Rezoning Transportation Analysis

Petition Number: 2023-147

Date	Description
12-27-23	First Review (IW)

Rezoning Plan
 Charlotte NC 28212

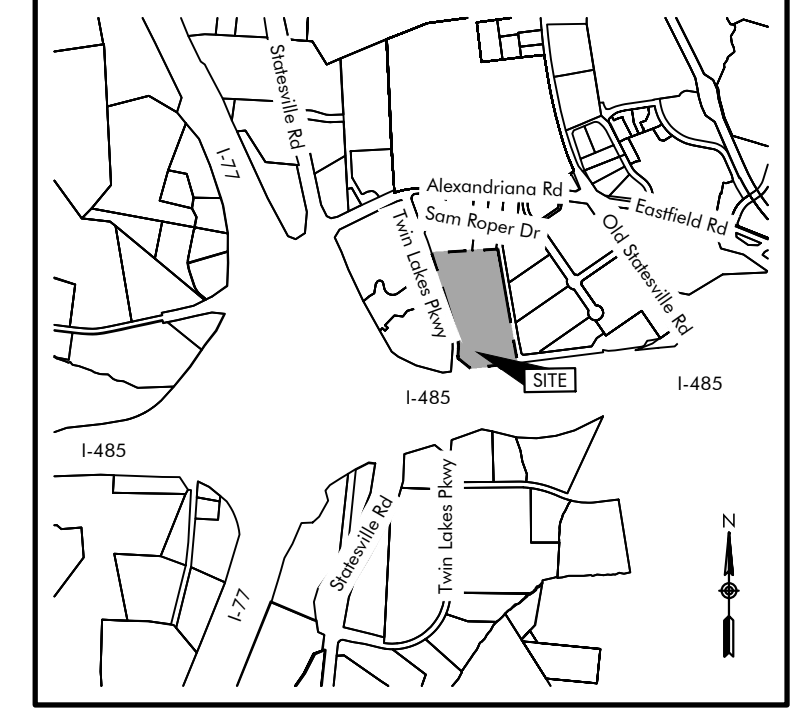
- a. **Twin Lakes Parkway:** Location of future curb and gutter is to be 17 feet from centerline.

CLDSM standard U-06 based on Table 33-2 in UDO

Label and dimension the curb and gutter from the centerline for each road on the site plan.

3. Revise site plan and conditional note(s) to commit to dedicate 31.5 feet of right-of-way from the Twin Lakes Parkway road centerline. The site plan shall label and dimension the right-of-way from the road centerline.

8. Revise site plan and conditional note(s) to construct 8-foot planting strips and 6-foot sidewalks on Twin Lakes Parkway. The site plan shall label and dimension both items from the back of curb and gutter or edge of pavement. Add conditional note The entire facility must be outside of the right of way and within a public access easement. Add conditional note committing to construction and maintenance of the 6-foot sidewalks on Twin Lakes Parkway.
